**Wyong Hospital Expansion (SSD 9536) – 664 Pacific Highway, Hamlyn Terrace  
Notice of Exhibition**

Thank you for your correspondence dated 25 February inviting Transport for NSW (TfNSW) comment on the subject State Significant Development (SSD 9536) Application.

## **TAB A – Detailed Comments on State Significant Application SSD (9536)**

**Figure 3.6: Local cycling facilities**

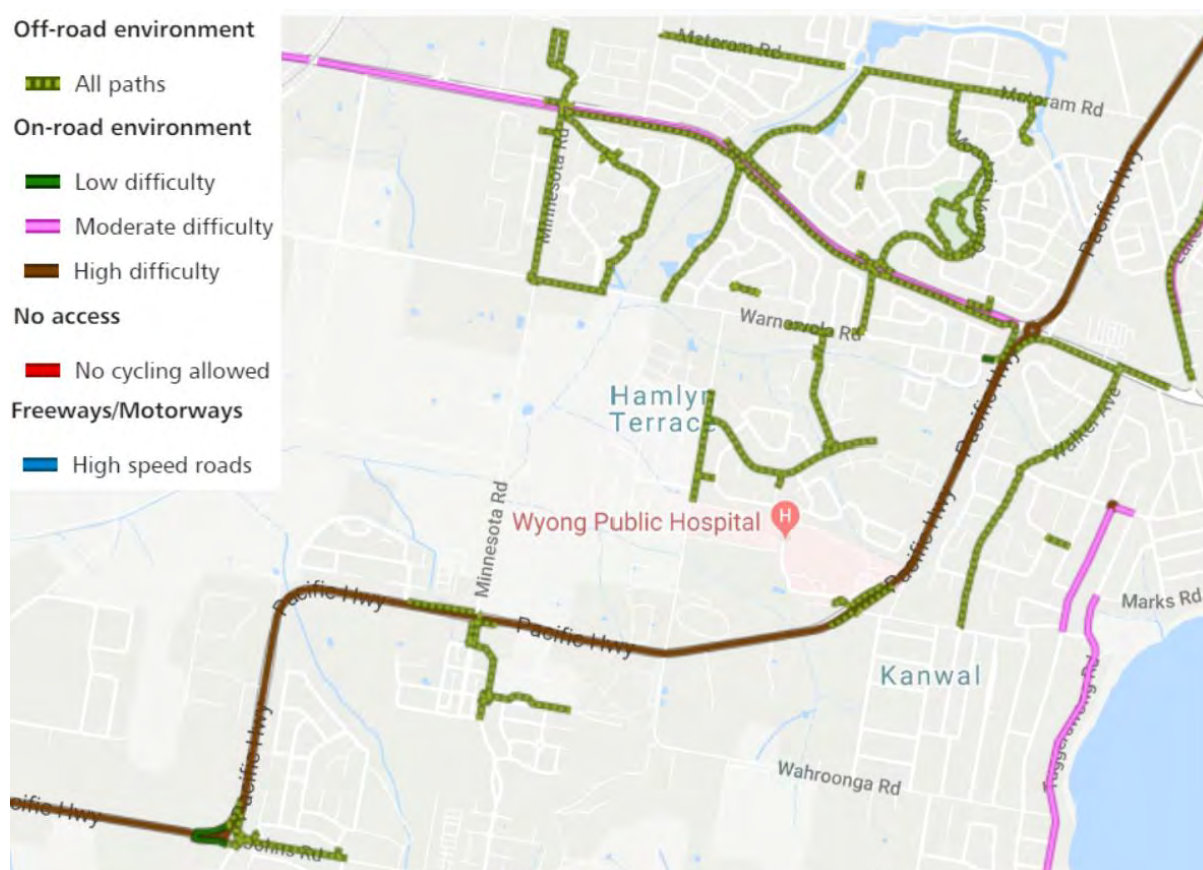
Figure 3.1 of the Green Travel Plan identifies a '*potential Hospital on road cycle link*' which would provide a cycling connection from the Pacific Highway to the Hospital. The Transport and Accessibility Assessment notes in Section 3.4.2 - Cycling Facilities, that there is a '*shared path*' present at the hospital entrance, off the Pacific Highway, that provides '*cyclists and vehicles alike*' access to the hospital. As a shared path typically denotes a path shared by pedestrians and cyclists, clarification is required regarding whether the potential hospital on road cycle link is part of the existing shared path connection.

The Applicant is requested to provide clarification on whether the potential hospital on road cycle link is part of the existing link, or if new works will be potentially undertaken to create an on-road cycling path.
